Development Facilitation Team (DFT) – Review Comments

Project No: PR-2019-003158 Date: 01/10/2024 Agenda Item: #4 Zone Atlas Page: C-20

Application For: SD-2024-00003-PRELIMINARY/FINAL PLAT (DHO)

REQUEST: DEDICATION OF ADDITIONAL STREET RIGHT-OF-WAY TO THE CITY OF ALBUQUERQUE

Site Plan of  
 Tracts B-1 and B-2, Block 19, Tract 3, Unit 3  
**North Albuquerque Acres**  
 Section 17, Township 11 North, Range 4 East, N.M.P.M.  
 Albuquerque, Bernalillo County, New Mexico  
 August 2023

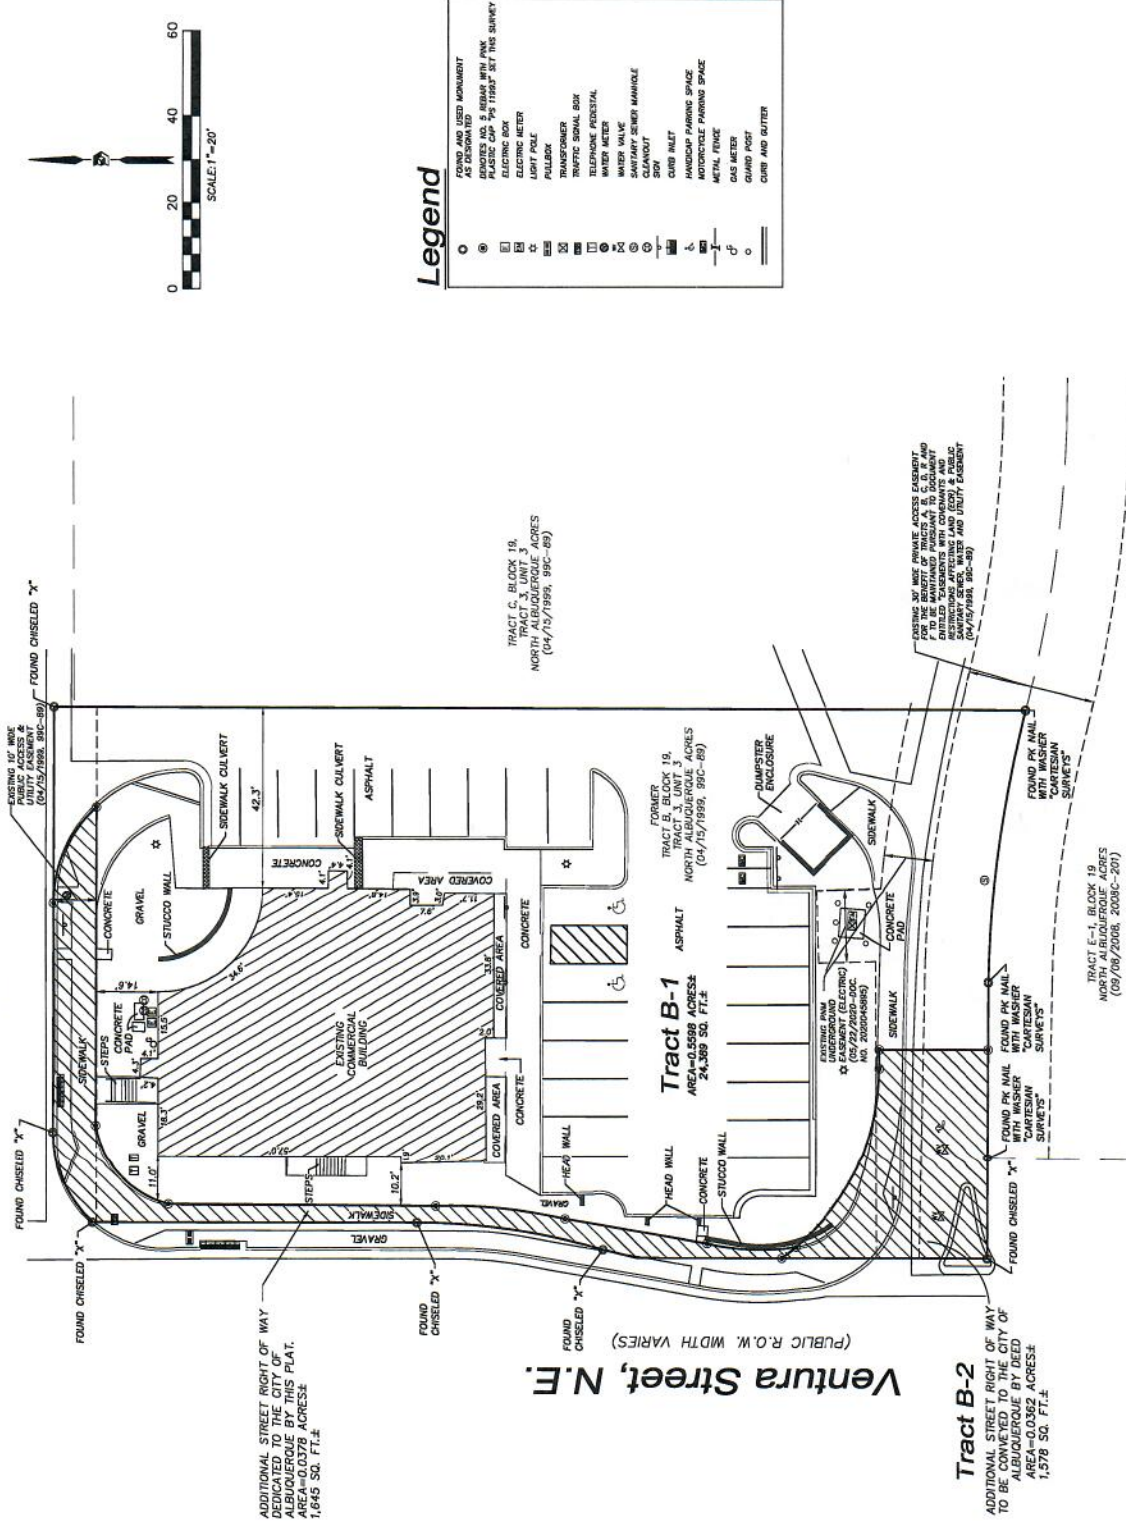
- Explain the purpose for the existing landscape area and sidewalk that are being partially dedicated as right of way.
- Explain if any infrastructure improvement is needed for this project. If Infrastructure is needed, an IL-Infrastructure list, and/or IIA-Infrastructure Improvements Agreement with financial guarantee will be required.
- Project and application numbers must be added to the Plat prior to final sign-off by DFT staff.
- Per 6-6(L)(2)(d)(7) of the IDO, the date of the DHO approval shall be recorded on the Final Plat. Therefore, prior to final sign-off of the Final Plat, the date of the DHO approval must be added to the Plat.
